ADD: PCD File No. BOA261

Subject: Request for Dimensional Variance for Existing Accessory Structures

Property Address: 422 Niagara St, Colorado Springs, CO 80911

Title, "SITE PLAN"

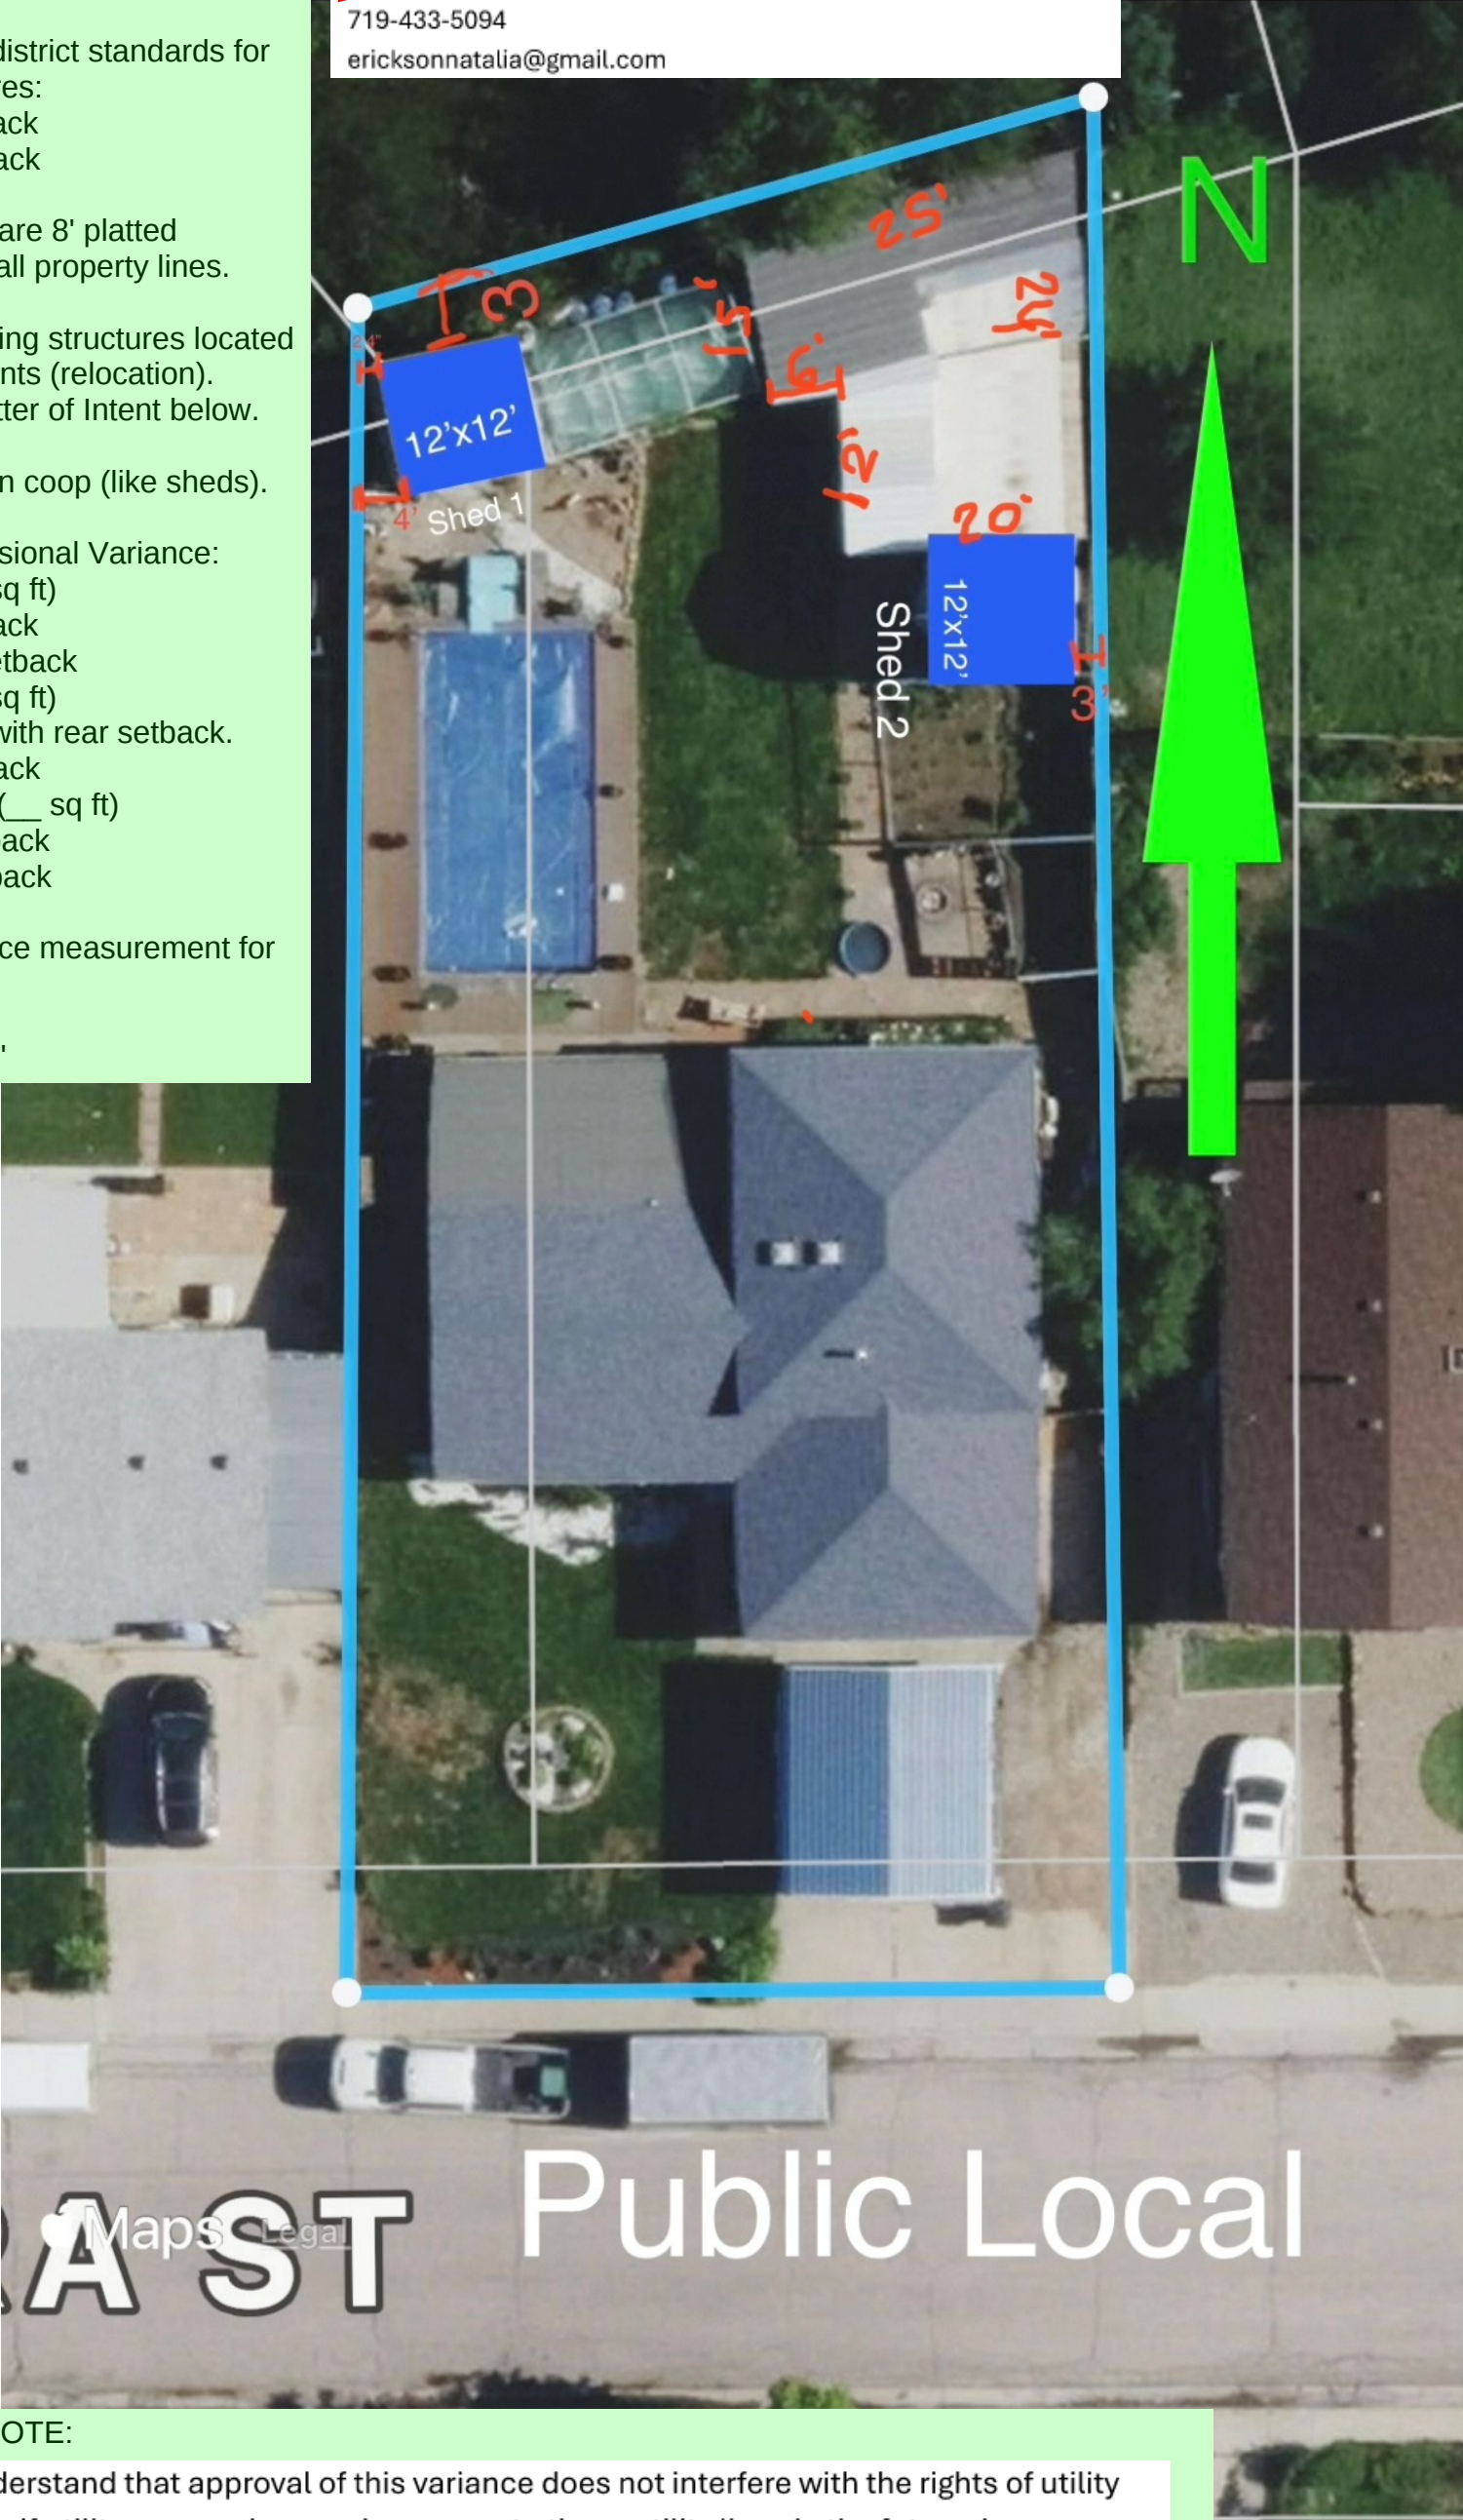
ADD: The dimensional standards of the RS-5000 zoning district requires that all accessory structures be located at least 5 feet from all rear and side property lines.

ADD: Specify what the actual dimensional variance request will accommodate for each structure. Identify the height of each structure.
